AGL - NEWCASTLE POWER STATION (SSI-9837)
OLD PUNT ROAD TOMAGO - Response to Submissions

I refer to your advice inviting comment on the Response to Submissions (RTS) exhibited on the NSW Department of Planning, Industry & Environment web site in relation to the Newcastle Power Station SSI-9837). Hunter New England Population Health (HNEPH) has reviewed the RTS and makes the following comments for your consideration.

Figure 7.7: Incremental annual average PM_{2.5} predictions – Gas Turbine Option (µg/m³)

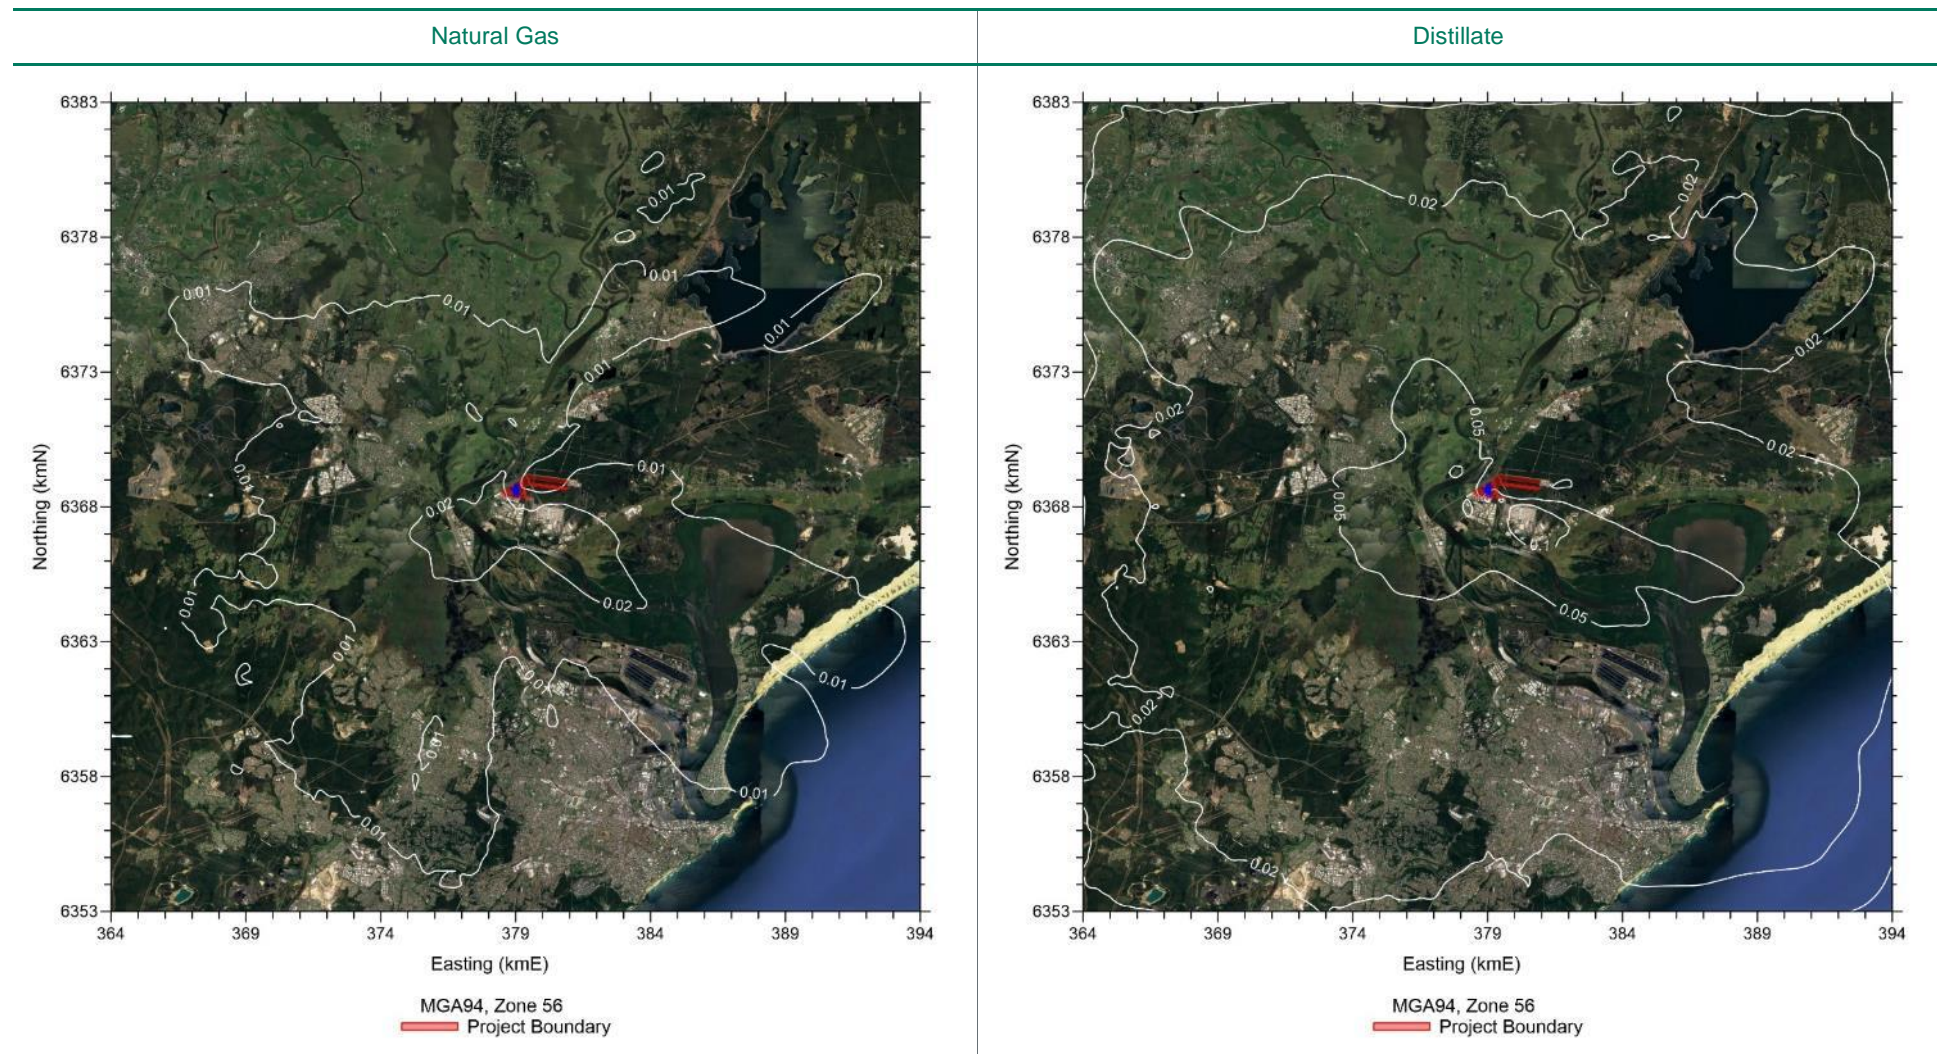
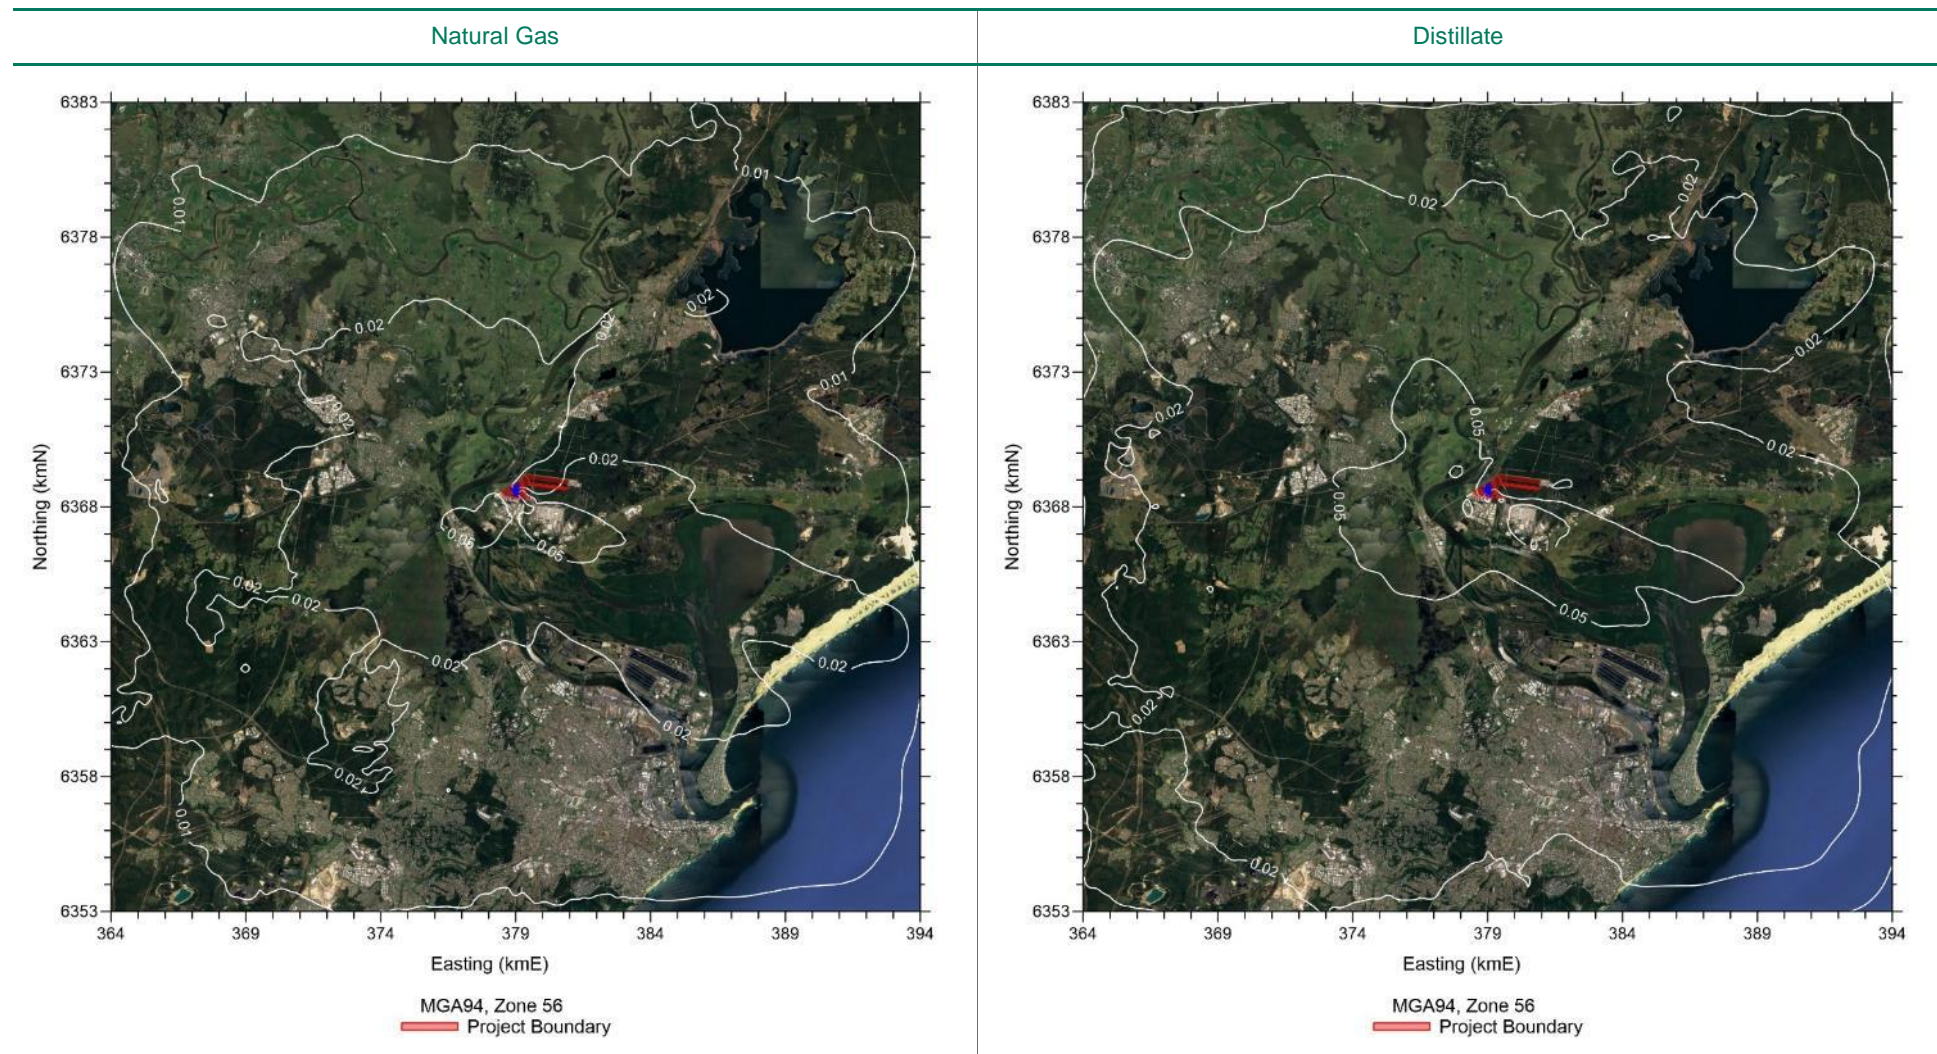
- (1) When taking into account the cumulative air quality impacts, the air shed appears to be at the limit for PM_{2.5} annual (at 8.1µg/m³) and while this development will add only a small increment (to 8.3µg/m³), the air shed already exceeds the PM_{2.5} maximum annual concentration standard.

- (2) It is noted also that the NEPC has included a reduction in long-term PM_{2.5} targets as a simplified approach for an exposure-reduction framework, bringing the annual average target to 7 µg/m³ and the 24-hour target to 20µg/m³, to be achieved by 2025."

The point of our comment in (1) above is that the background levels are already elevated, and that is an argument for not increasing inputs into the air shed with resulting negative impacts on human health. The proponent has interpreted elevated background levels as a justification for increasing levels. While minor in itself, the total air shed impact is comprised of multiple minor inputs.

The proponent's response to (2) above, is to note the current guideline level, to which they are not ensuring compliance, and does not express an intention to comply with the more stringent future pollution goals.

We would seek the proponent's commitment to modify the proposed process to ensure that the proposal does not contribute to exceedances of current or future PM_{2.5} standards in Newcastle. A key interest in assessing the future impacts of this development, will be in whether it can meet future national goals.
